Morgan Offshore Windfarm Generation Assets Case Team
Planning Inspectorate
morganoffshorewindproject@planninginspectorate.gov.uk
(Email only)

MMO Reference: DCO/2022/00003
Planning Inspectorate Reference: EN010136
Identification Number: 20048964

Planning Act 2008, BP Alternative Energy Investments Ltd, Proposed Morgan Offshore Windfarm Generation Assets Order

Deadline 5

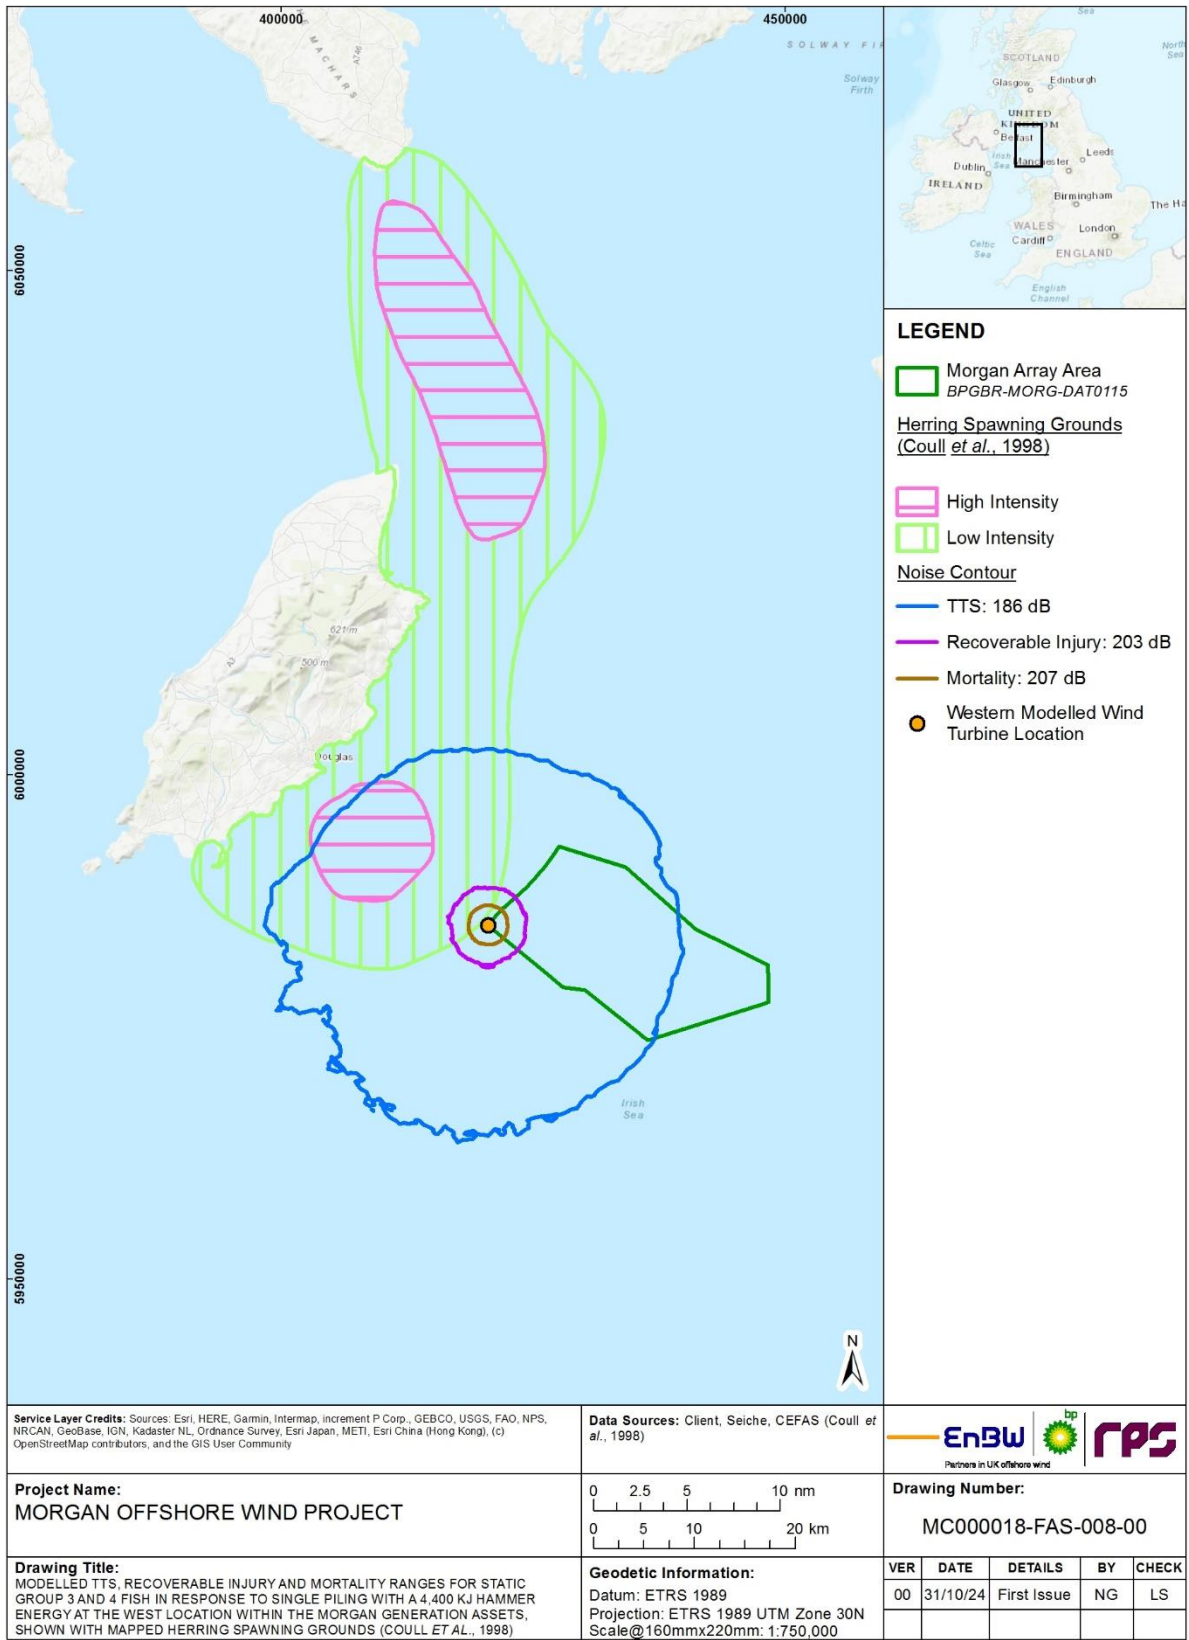
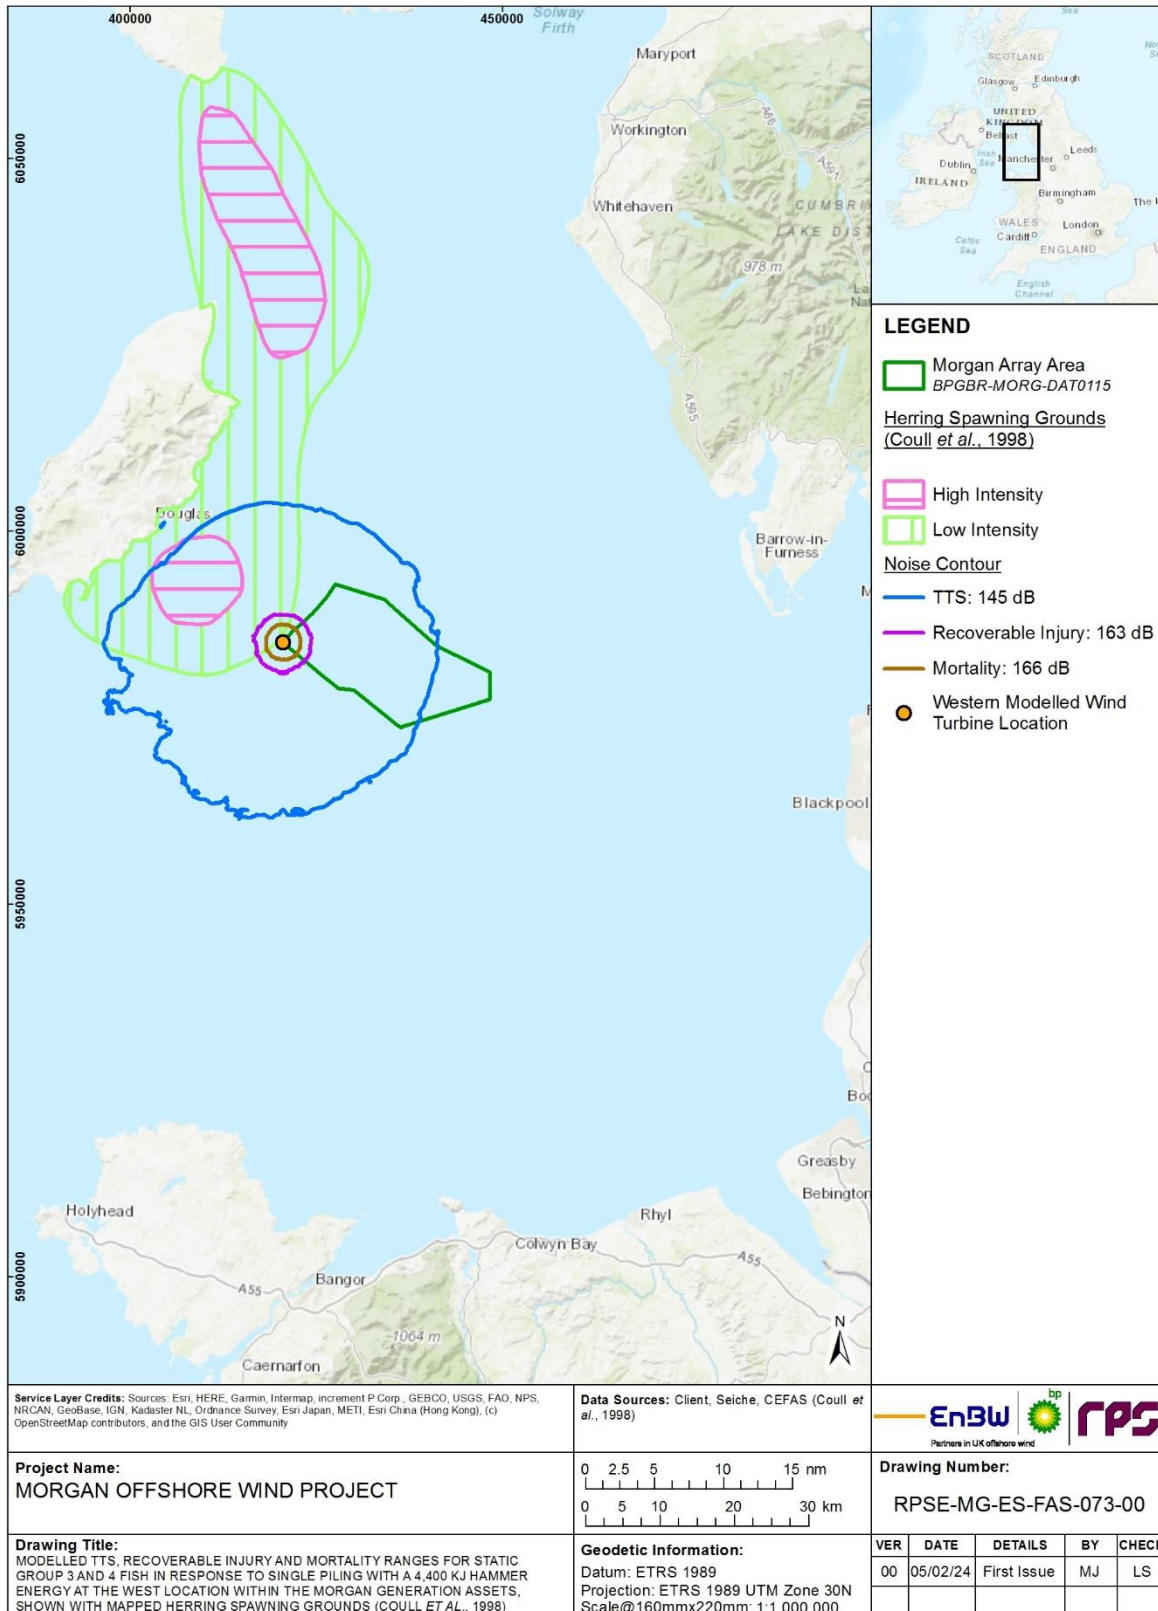
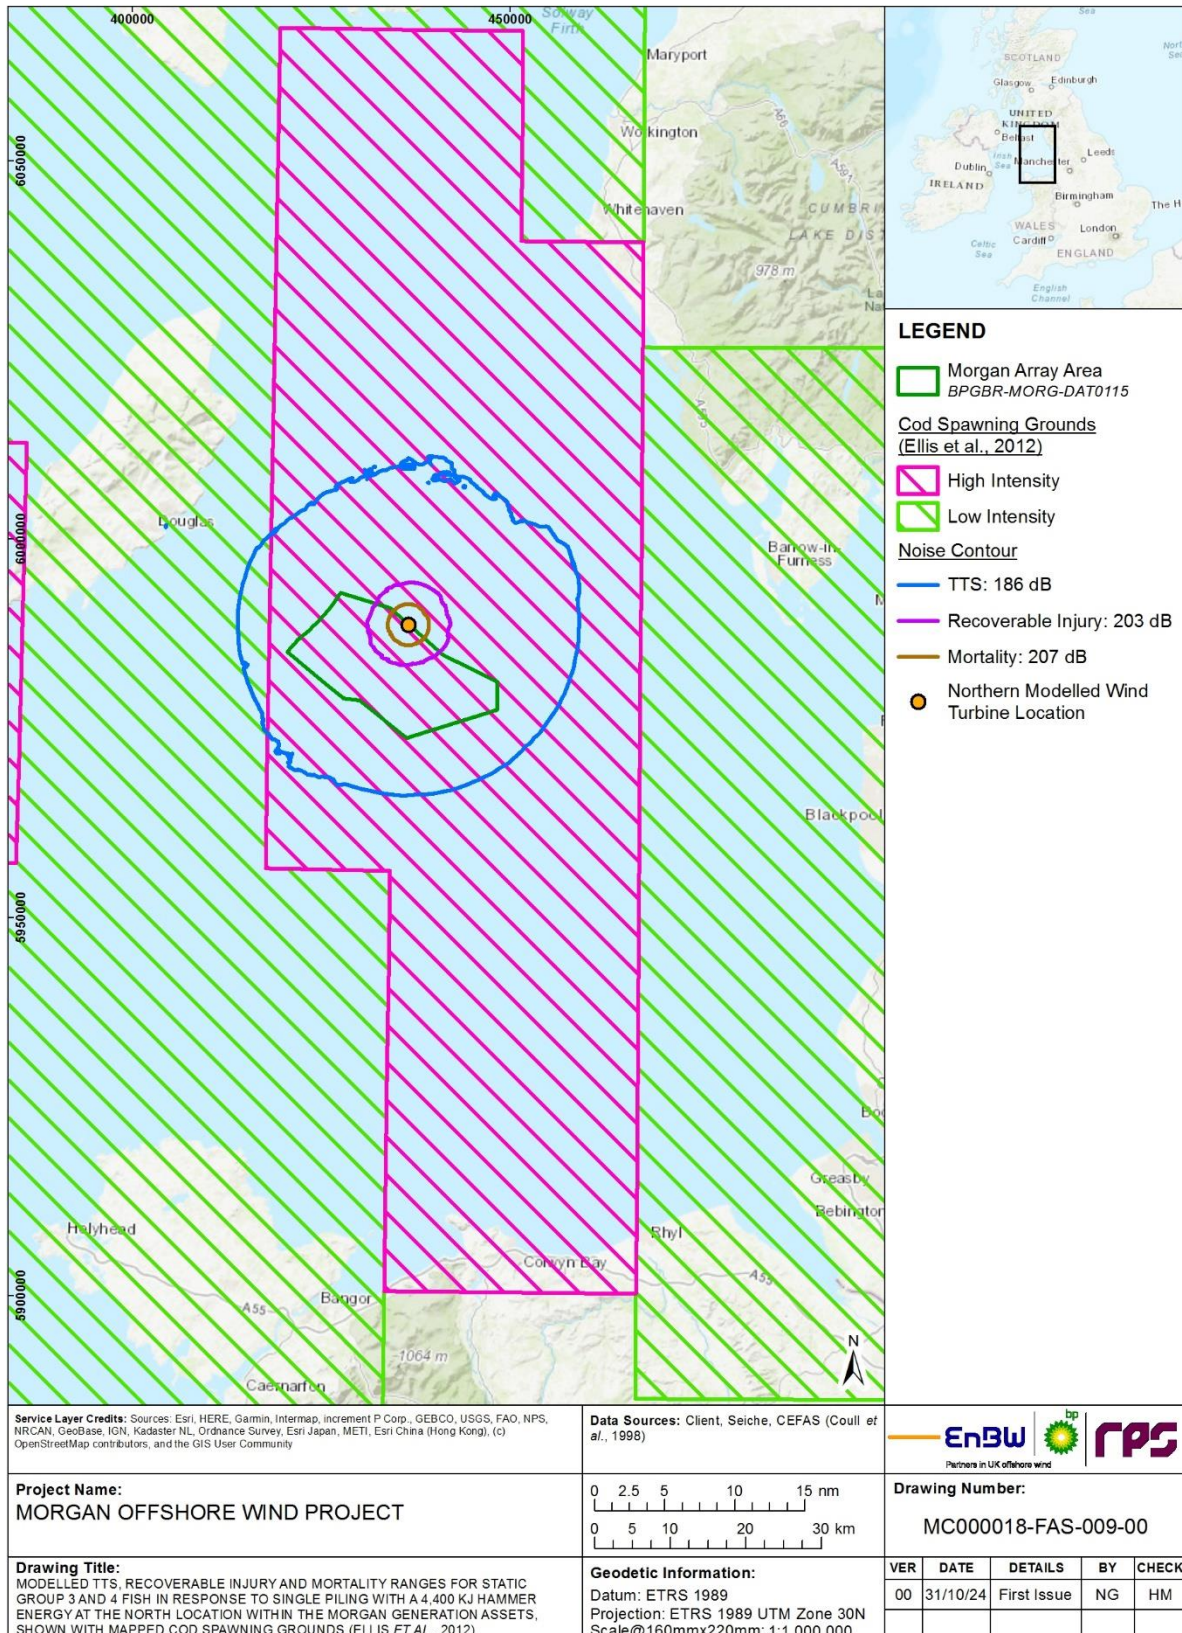
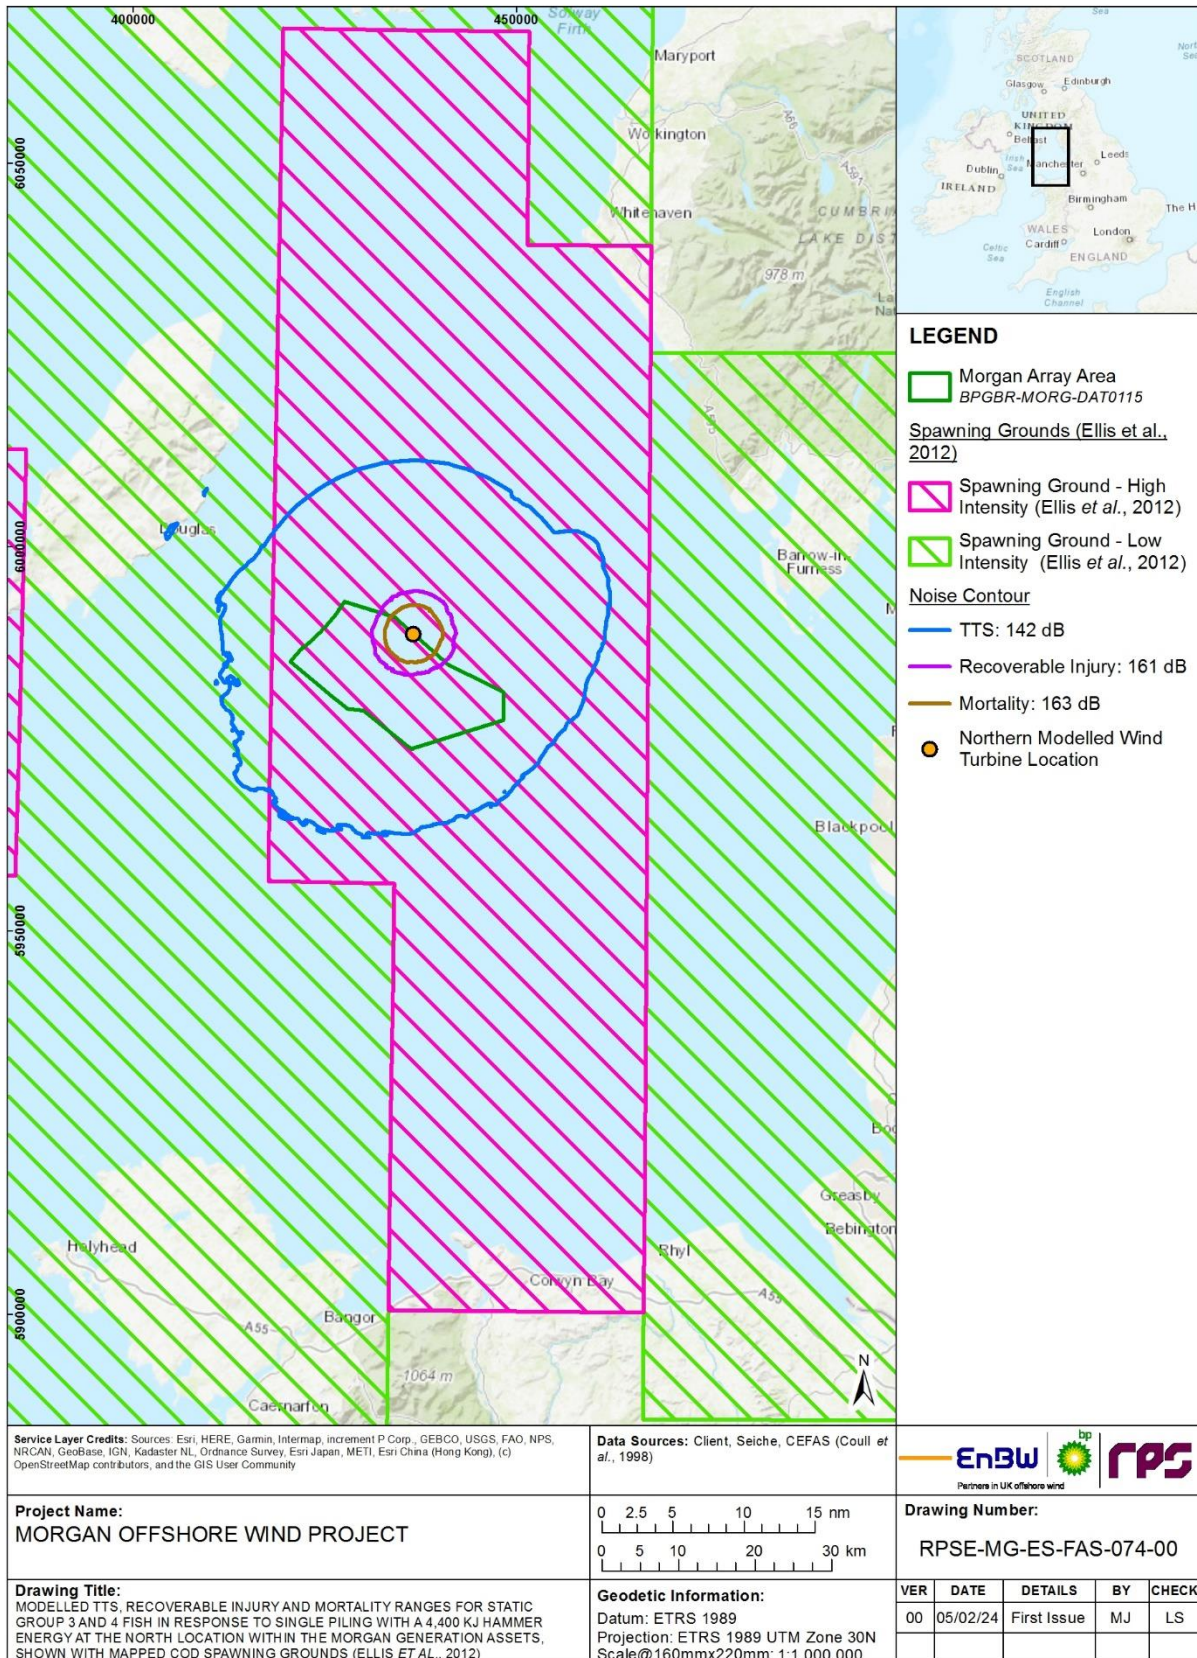
<p>been inferred in the different figures; for example, Figure 3.10 displays a TTS contour of 145 dB for a static receptor whereas Figure 3.11 displays noise contours of 142 dB for TTS for a static receptor. The MMO requests that the modelling outputs presented in Figures 3.8, 3.9, 3.10 and 3.11 of the fish ecology chapter be amended. The MMO requests that the Applicant presents the range of impact from UWN based on the thresholds for Group 3 fish with high hearing sensitivity for mortality and potential mortal injury (207 cumulative sound exposure level (SELcum)), recoverable injury (203 SELcum), and TTS (186 SELcum) as per the pile driving threshold guidelines described by Popper et al. (2014).</p>		
REP2-029.90	<p>Outline Marine Mammal Mitigation Protocol (MMMP)</p> <p>The MMO notes that the UWSMS is a live document which will be updated through discussions with stakeholders, and, if NAS is required, will include this detail clearly in the final MMMP and UWSMS. As per MMO's original comment, the MMO requests that NAS (bubble curtain) is required for ALL high order clearance, and it is in the interest of the Applicant to plan for this at the earliest opportunity. The MMO would also highlight that this is consistent with the standard requirements within the conditions for all 2024 and 2025 UXO marine licences.</p>	<p>The Applicant notes the MMO's Written Submission. The Applicant re-iterates that the Applicant will follow any published guidelines on noise abatement at the time the UWSMS (APP-068) is finalised. As highlighted by the MMO, the UWSMS (APP-068) is a live document which will be updated through discussions with stakeholders, and if there is a requirement to use NAS, the Applicant will include this detail clearly in the final UWSMS (and the final MMMP), which will be discussed with stakeholders and agreed with MMO prior to commencement of construction. The Applicant highlights the discussion held with the Applicant, the MMO, Cefas and Natural England (24/10/2024) in which REP2-029.90 was raised. Following this discussion, it is the Applicant's understanding that the MMO consider that the development and finalisation of the MMMP and UWSMS (APP-068) are considered sufficient to manage</p>	<p>The MMO notes the Applicant's response. The MMO is content that the discussions will continue in the development of the UWSMS & MMMP. However, at this stage the MMO notes that some of the mitigation is known. As per the Defra interim position statement low order should be standard mitigation on UXO. It is the MMO's position that for high order UXO clearances bubble curtains must be used regardless of the size, and this should be reflected within the plans at this stage. The MMO also notes that JNCC and NE have concerns on UXO being included in the DML.</p> <p>The MMO delayed a further response on this point until Deadline 5 following a discussion with interested parties these concerns.</p>
